Consultation Response from: KC Environmental Health (Pollution & Noise Control)
2023/92034 - adj, 655, Halifax Road, Hightown, Liversedge, WF15 8HE
Discharge condition 4 (parking), 6 (materials), 8 (Phase I Desk Study Report), 9 and 10 Phase II Intrusive Site Investigation Report, 13 (charging electric vehicles), 16 (drainage) on previous permission 2019/93380 for erection of detached dwelling with associated parking and amenity space
**Date Responded:
26th September 2024**
**Responding Officer:
NH**
**Responding Ref:
WK/202430288**

Condition 13 – Electric Vehicle Charging Point (EVCP)

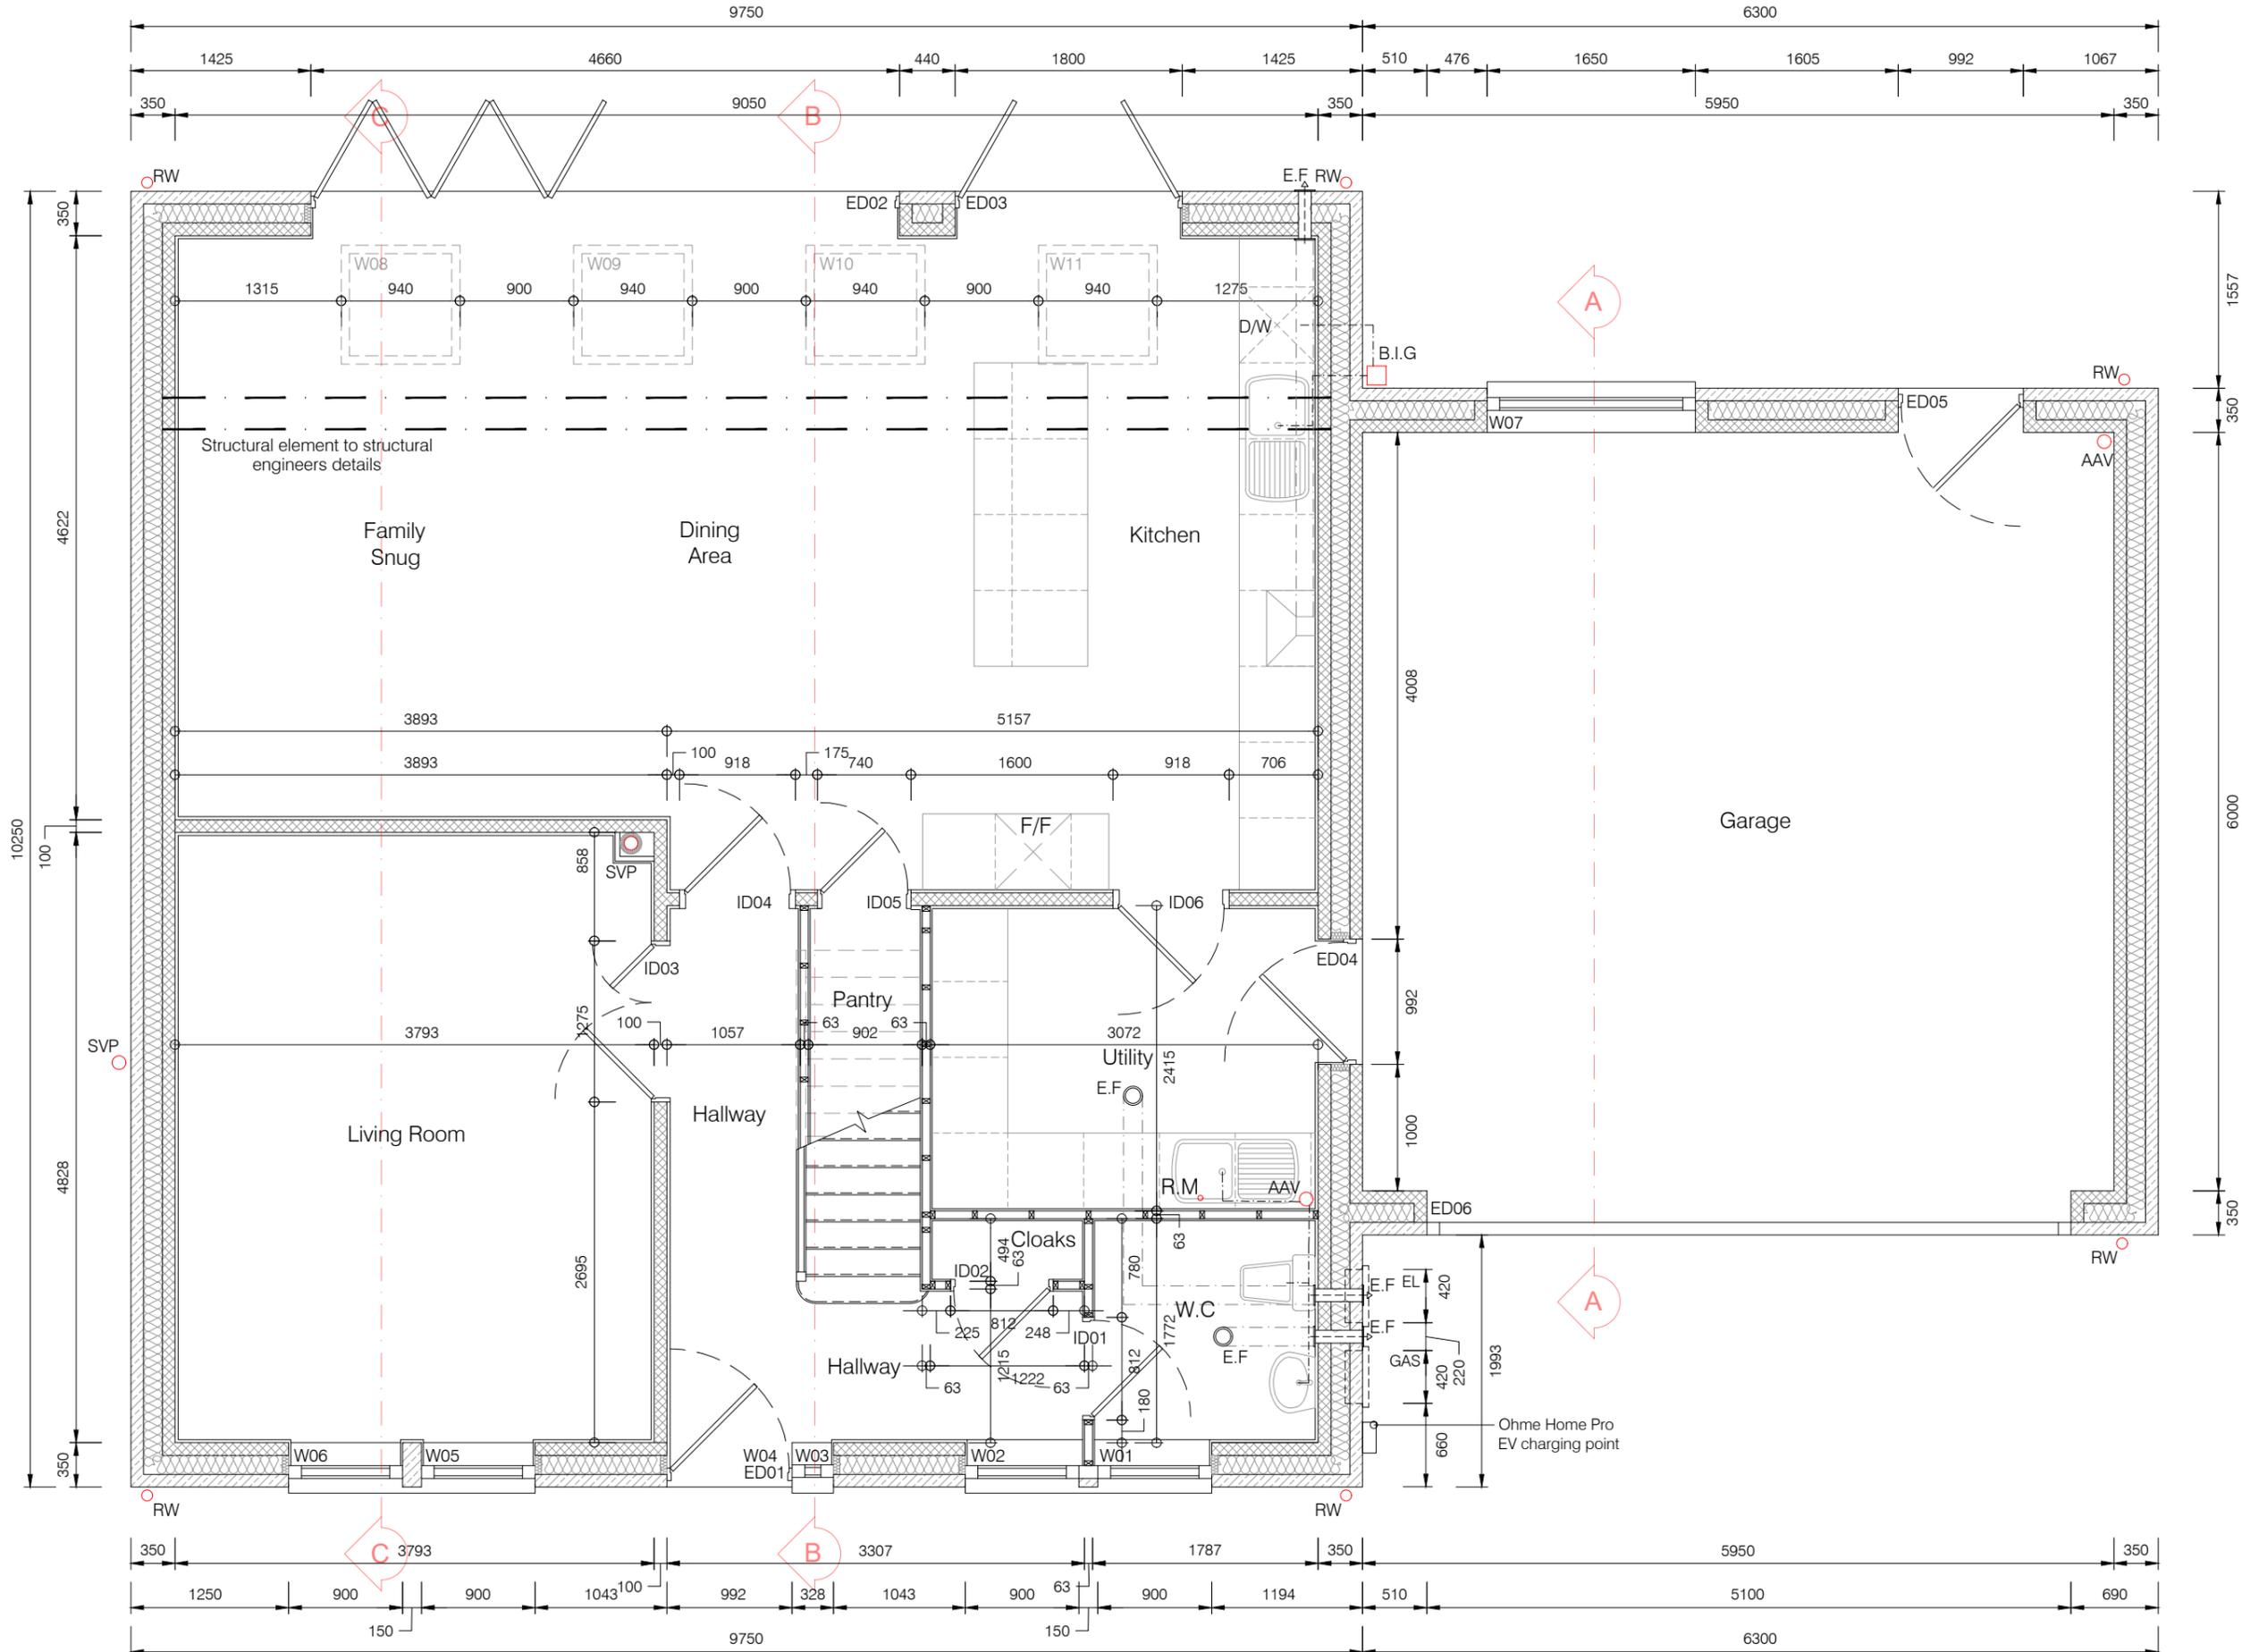
Further to the Proposed Ground Floor Setting Out Plan by Studio 91 Architecture dated April 2023 (Drawing no. BR-201) a technical specification file document has been received in support of Condition 13.

The plan showed the proposed installation of a Ohme Home Pro EV charging point. Several models are described in the document

The supporting documents do not appear to confirm the technical specification for the proposed EVCP. The applicant must confirm the chosen EVCP to the planning officer. Should this meet the technical specification above, then this would be satisfactory.

Condition 13 requires the installation of a Standard Electric Vehicle Charging point (of a minimum output of 16A/3.5kW) for each residential unit that has a dedicated parking space
